26 June 2023

Our Ref: R/2022/4/A
File No: 2023/369423
You Ref: SSD 39587022

Advice on EIS – Central Barangaroo Early Works – SSD 39587022

DA-01 Early Works - Hickson Road

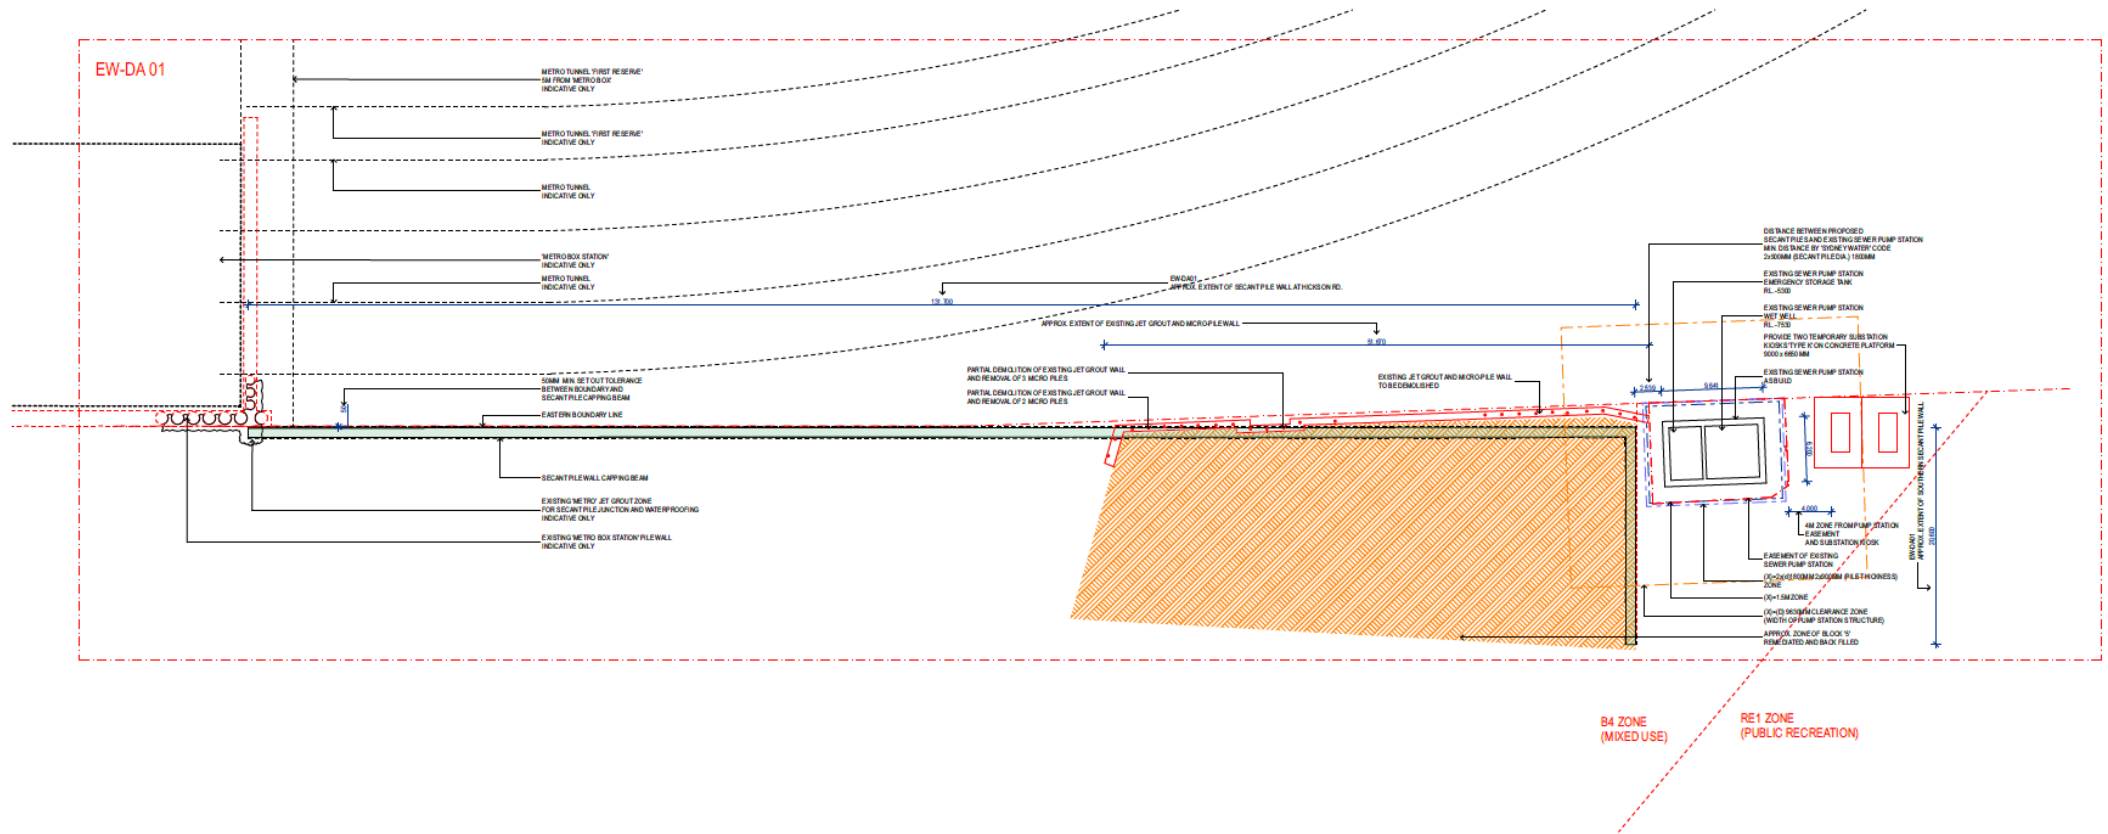
- The proposal requires the diversion of two existing stormwater lines. The lines are owned by Maritime Services Board and/or the City. Approval is to be sought from owners prior to any works.

- It is proposed to divert stormwater along Hickson Road. A full assessment and stormwater design should accompany any future submission. Any such proposal will have impact on Hickson Road and any future upgrade works.

- Levels of Hickson Road were noted to be assumed to be lifted to near 3.50m RL from around 2.60m RL. This significant lift in levels will impact upon levels and required ramping in the public domain at both ends of the affected area at Hickson Road, before transitioning back down to existing RLs.

- The top of the proposed retaining wall projects above the level of the existing public domain levels. Please confirm all proposed levels and consider impacts upon public access, tree planting, storm water and overland flow paths.
